REQUEST

Current Zoning: N1-A (Neighborhood 1-A)
Proposed Zoning: NS (neighborhood services)

Approximately 0.99 acres located at the southeastern corner of the intersection of Steele Creek Road and Rigsby Road.

The petition proposes to allow the development of a 4,000 square foot commercial building with accessory drive-through for all uses permitted in the NS zoning district.

RZ1.0

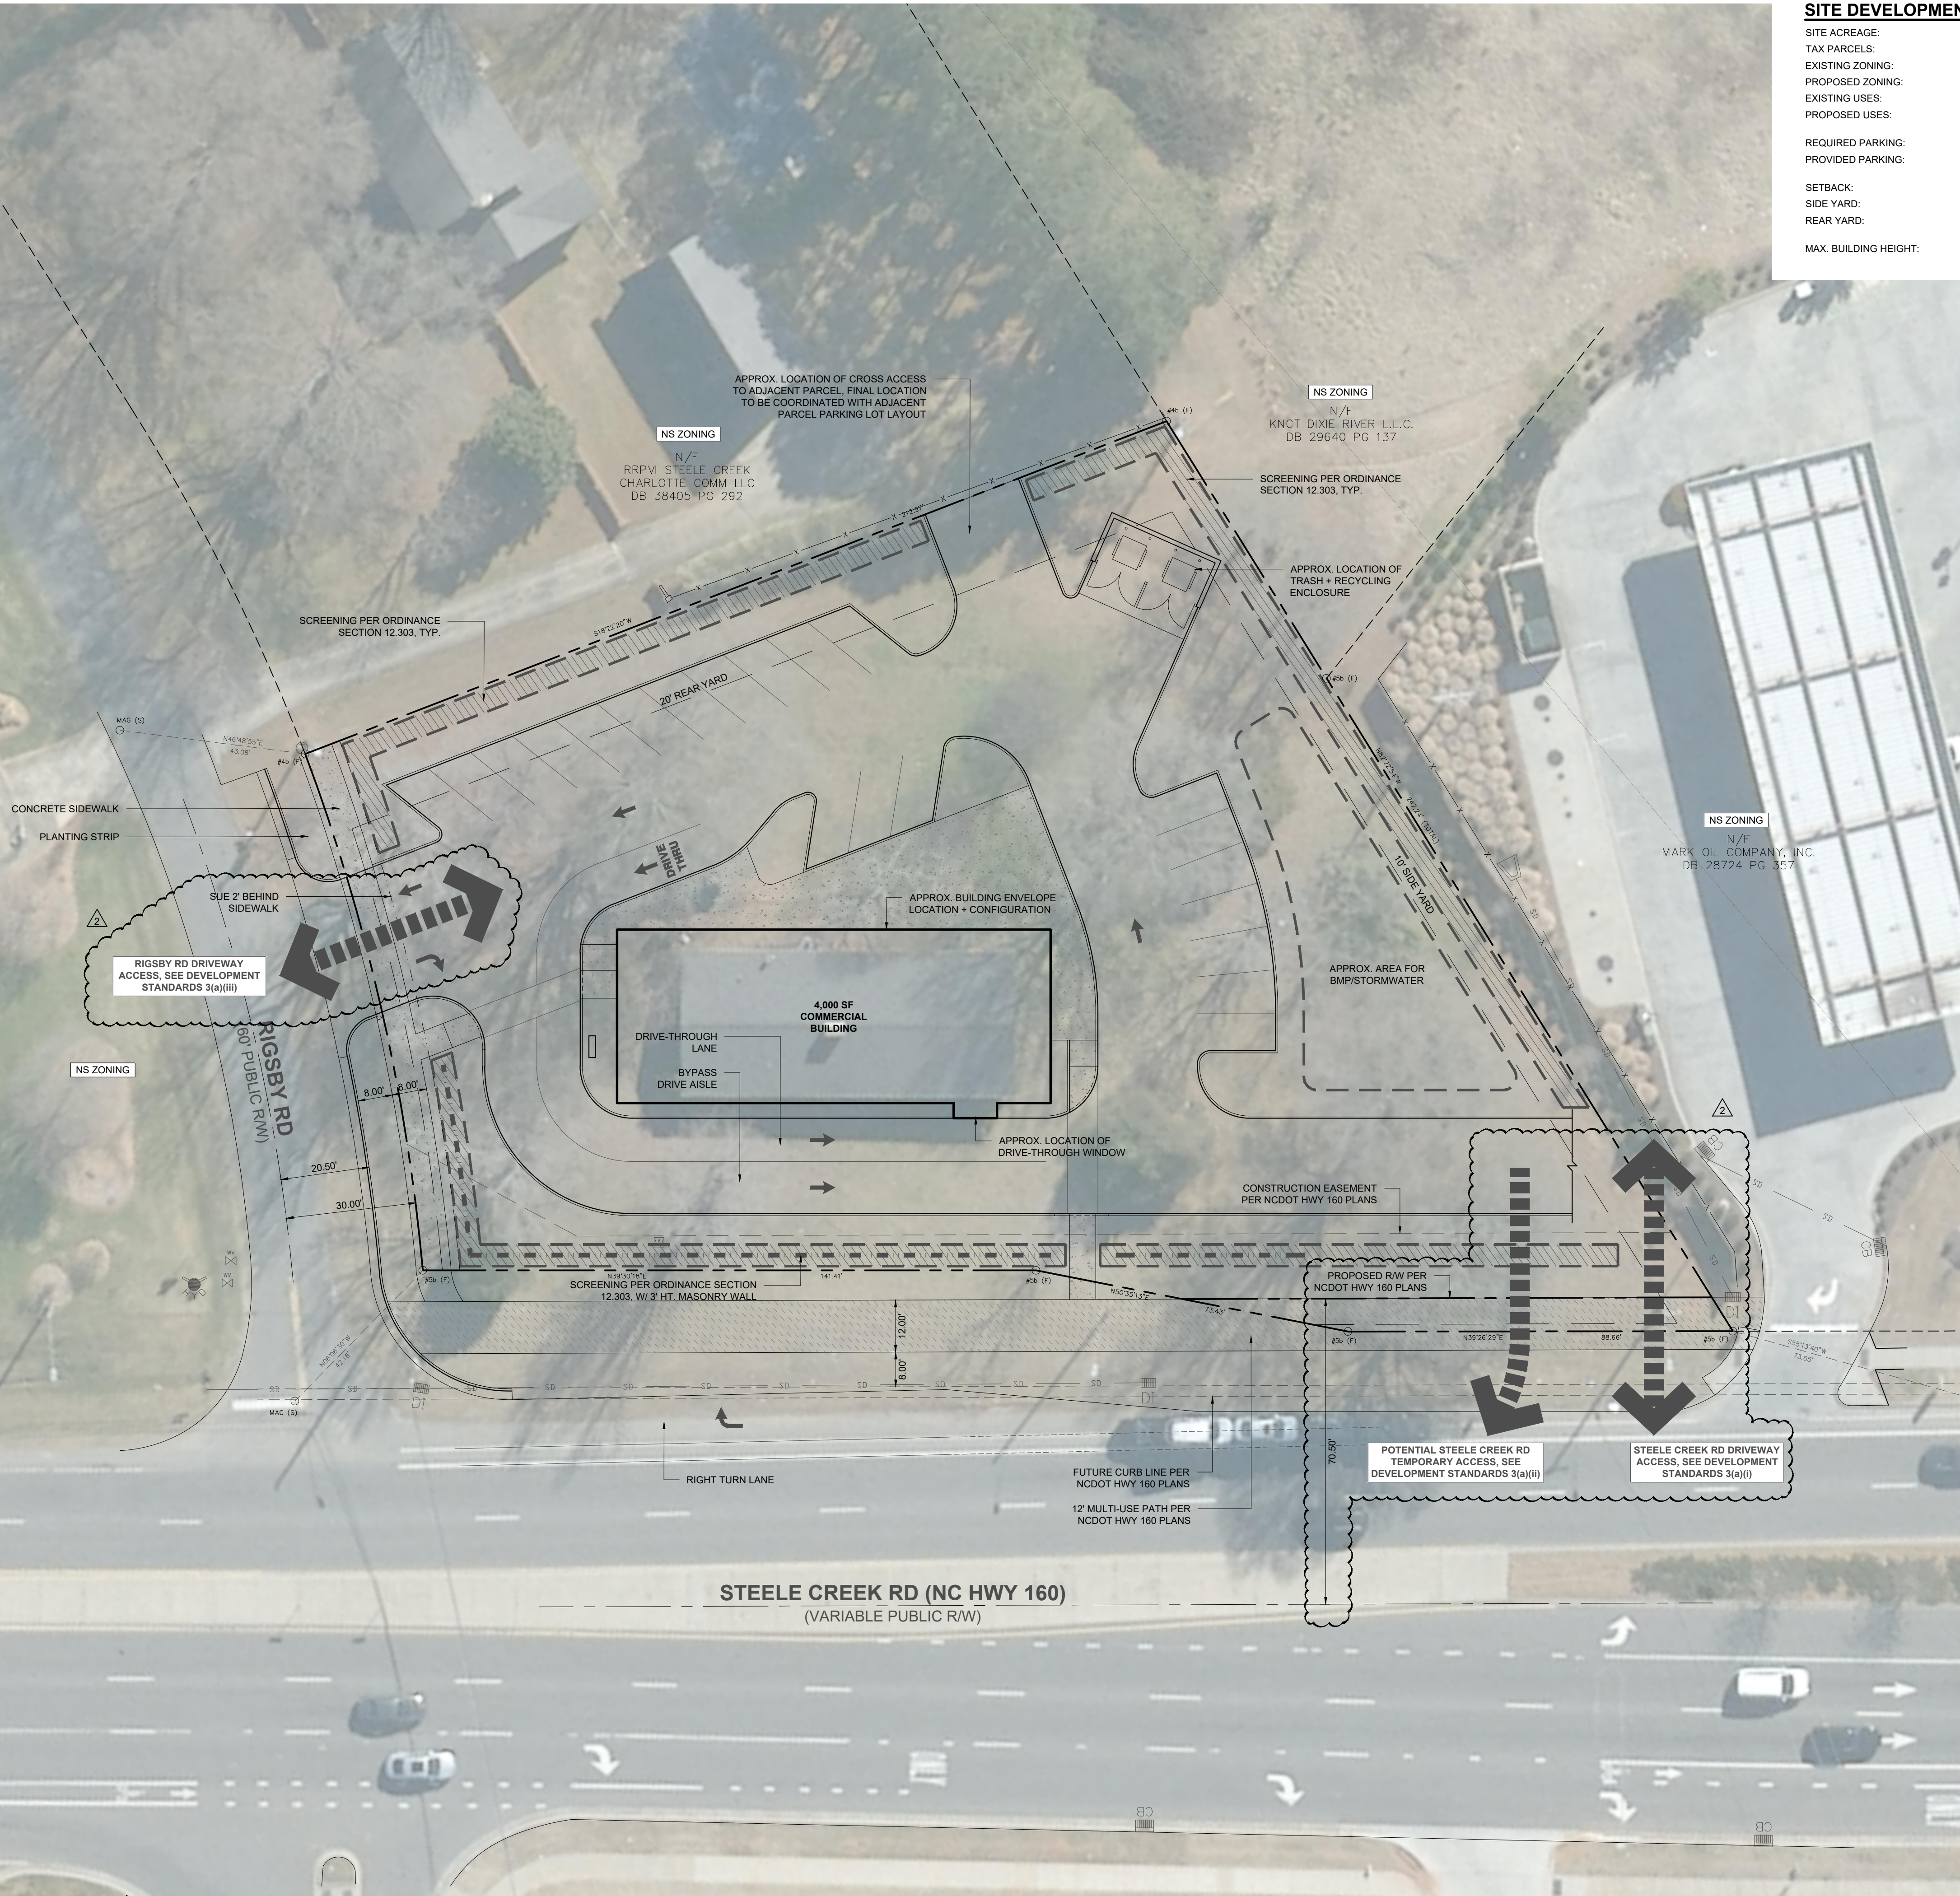
Site plan and conditional note revisions are needed and the outstanding items including, but not limited to labeling and dimension the right-of-way on Steele Creek Road, clarifying an unlabeled dimension on the site plan, and committing to providing an access easement with the adjacent parcel to provide cross-access. Further details are listed below.

- ~~1. Label and dimension the rights-of-way from centerline of Steele Creek Road and Rigsby Road.~~ **ADDRESSED**
- ~~2. Place a sidewalk utility easement 2' behind the sidewalk along Rigsby Road.~~ **ADDRESSED**
- ~~3. Revise the conditional notes by committing to provide an access easement, during permitting, with PID 20109114 to allow cross access as generally shown on the site plan.~~ **ADDRESSED**
- ~~4. Revise the site plan by clarifying the 6 foot dimension on the site's frontage of Steele Creek Road.~~ **ADDRESSED**
